**Lead Local Flood Authority**  
**Post Point CHN 215**  
**Hertfordshire County Council**  
**County Hall, Pegs Lane**  
**HERTFORD SG13 8DN**

Date 17 May 2023

**RE: 6/2022/2220/COND – Stadium Service Station, Stanborough Road, Welwyn Garden City AL8 6XA**

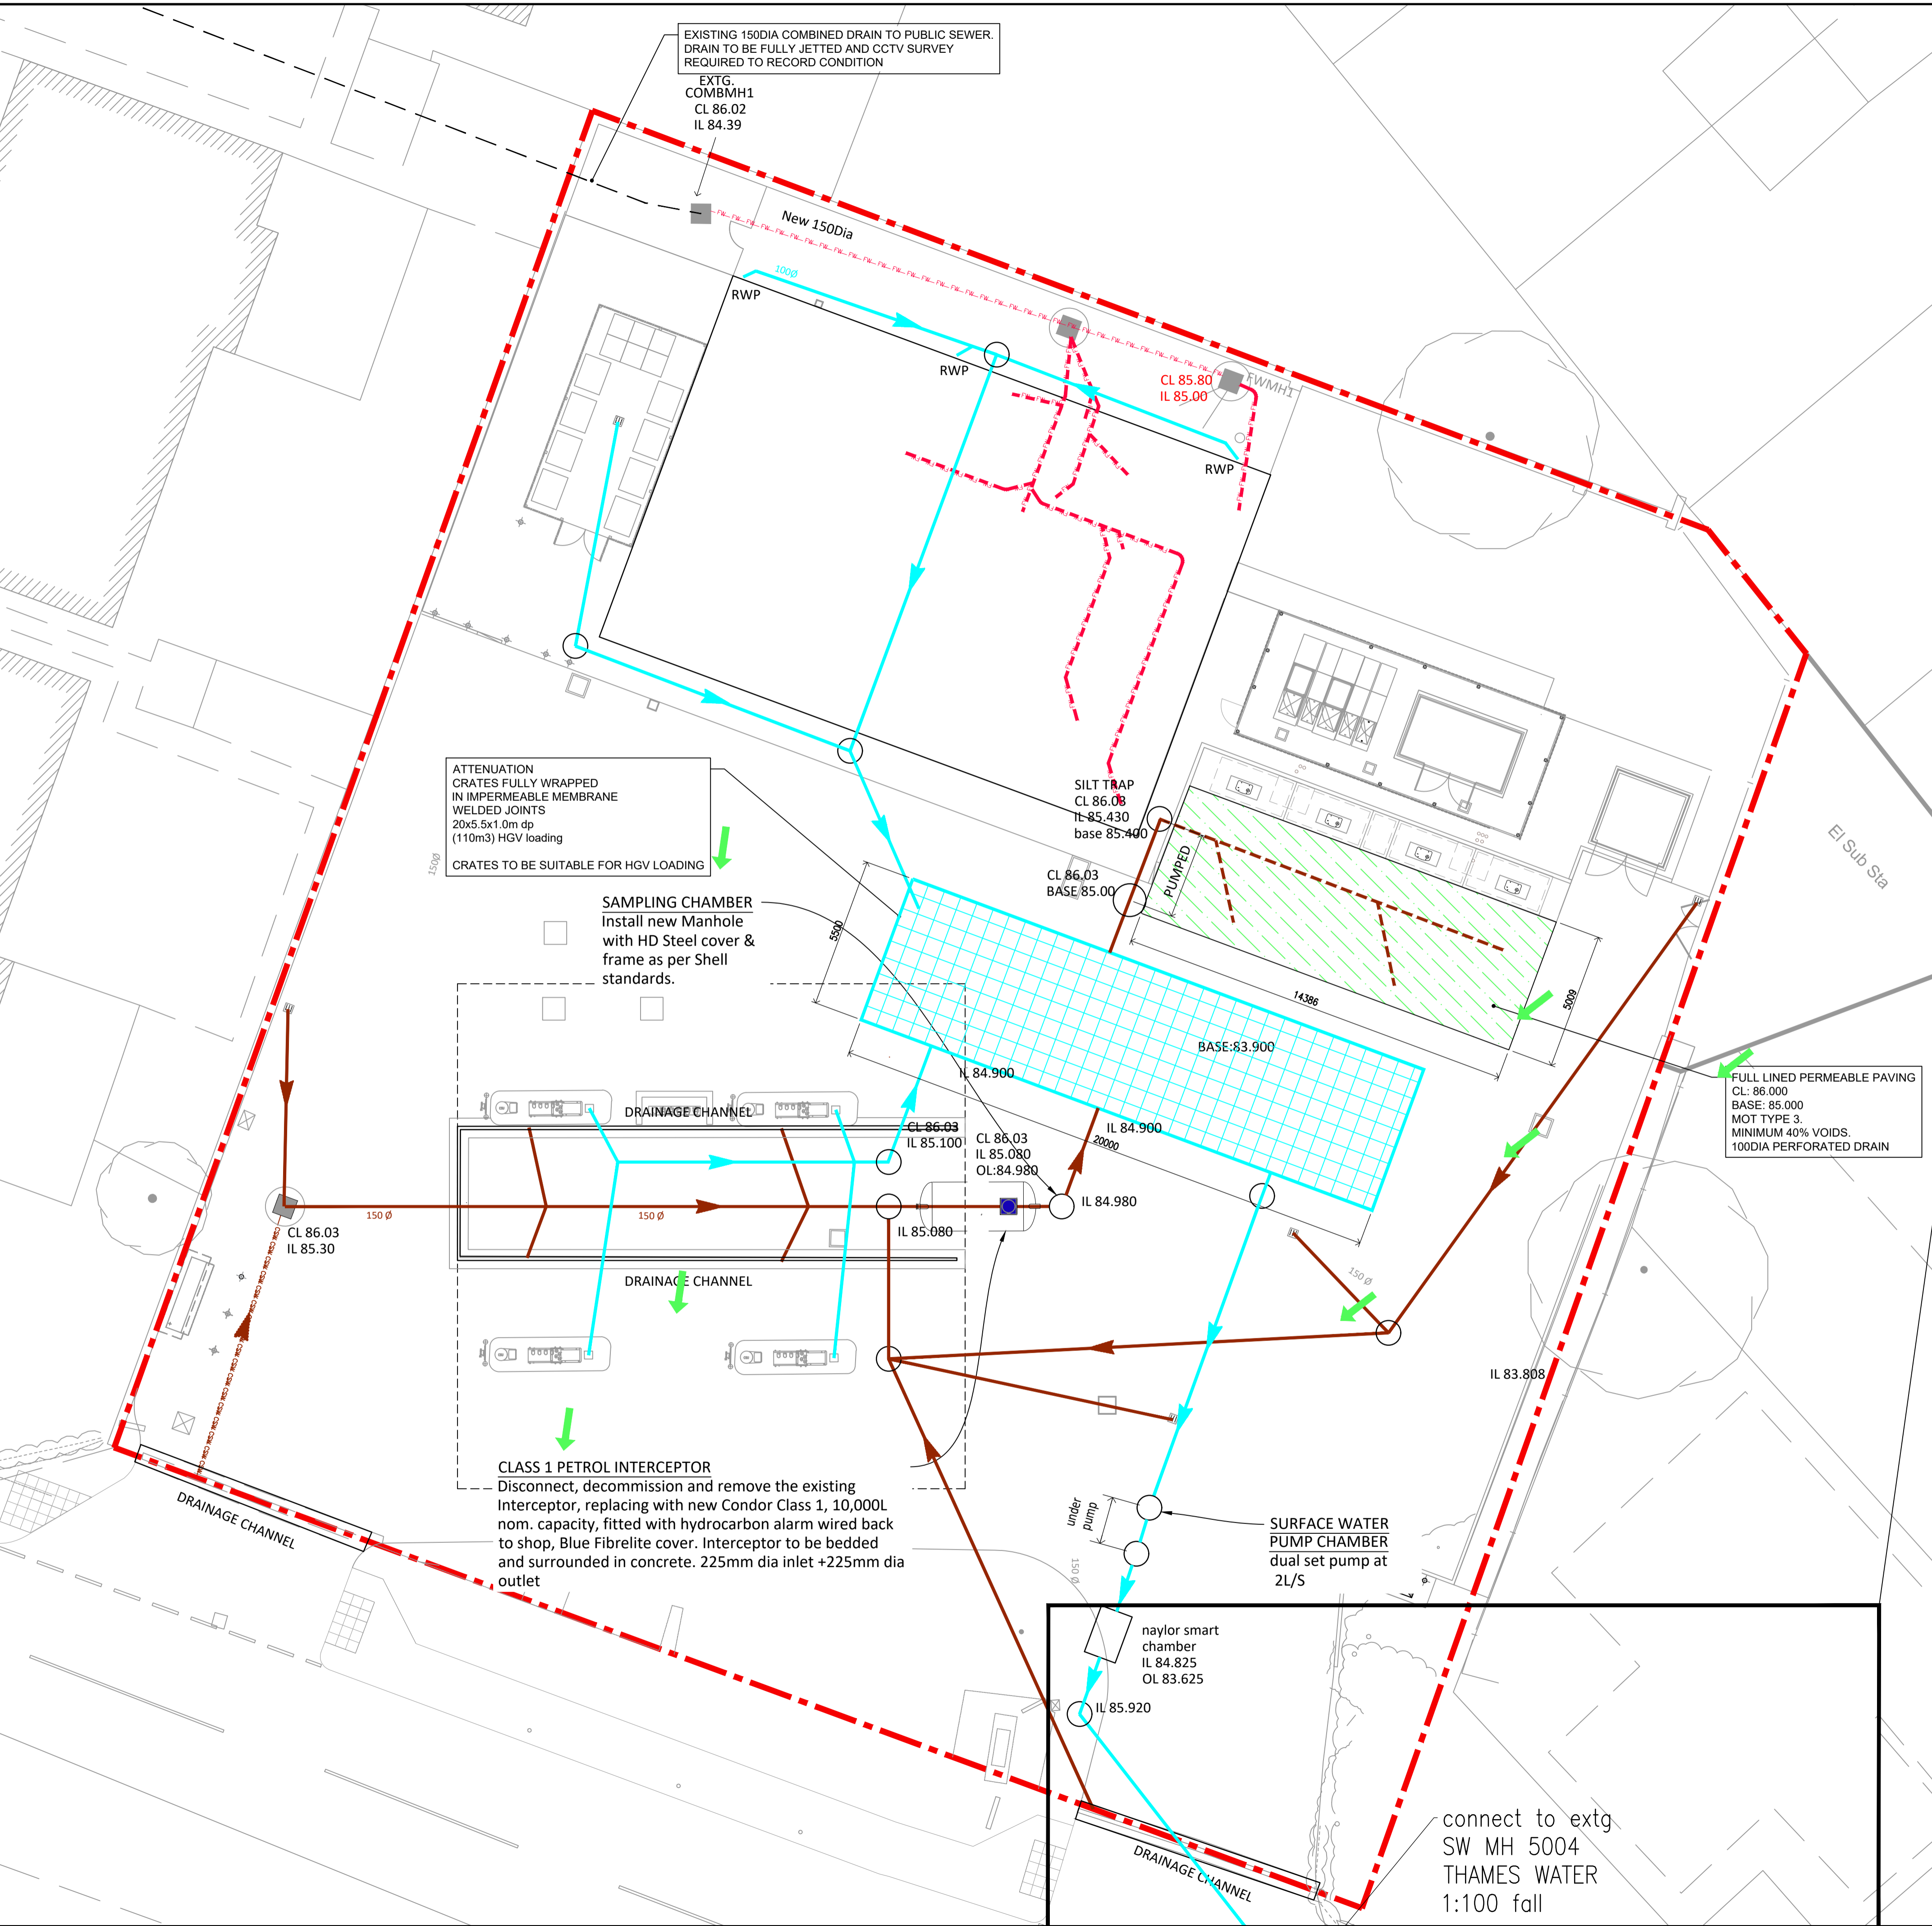
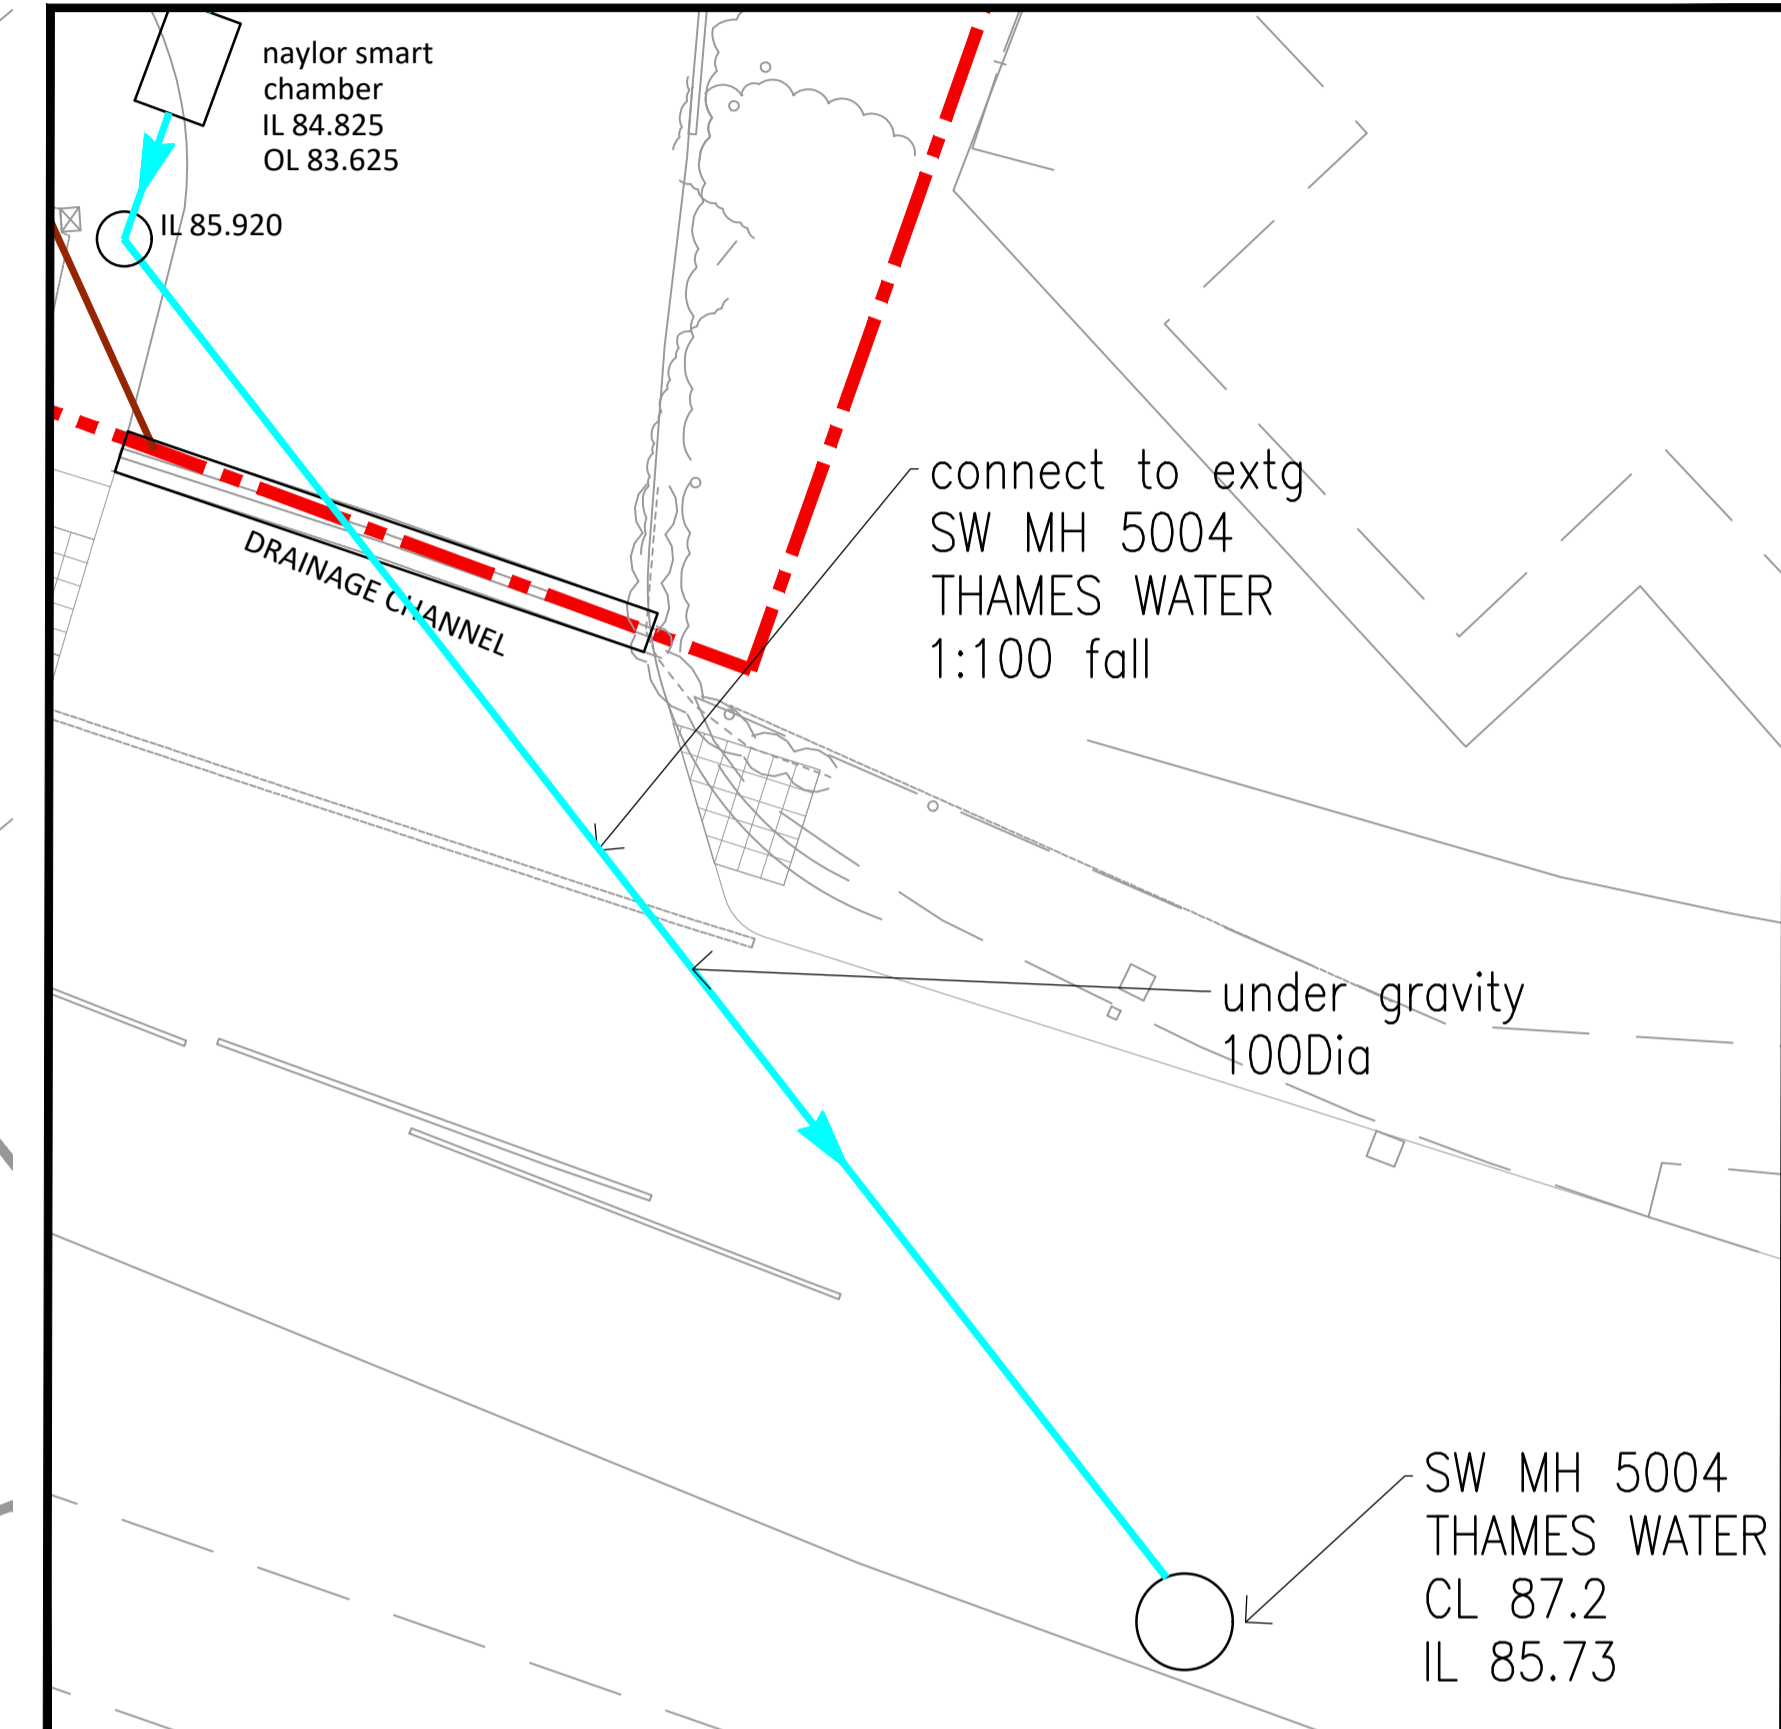
1. For Point 1 of Condition 2, in order to demonstrate that there is a viable surface water drainage system, the applicant is required to demonstrate the suitable application of the SuDS discharge hierarchy including appropriate supporting evidence. **Further information required.**
2. As per Point 4 of Condition 2, provision of detailed engineered drawings including cross and long section drawings of each of the proposed SuDS (permeable paving, swales, pond) and drainage features is required. **Further information required.**
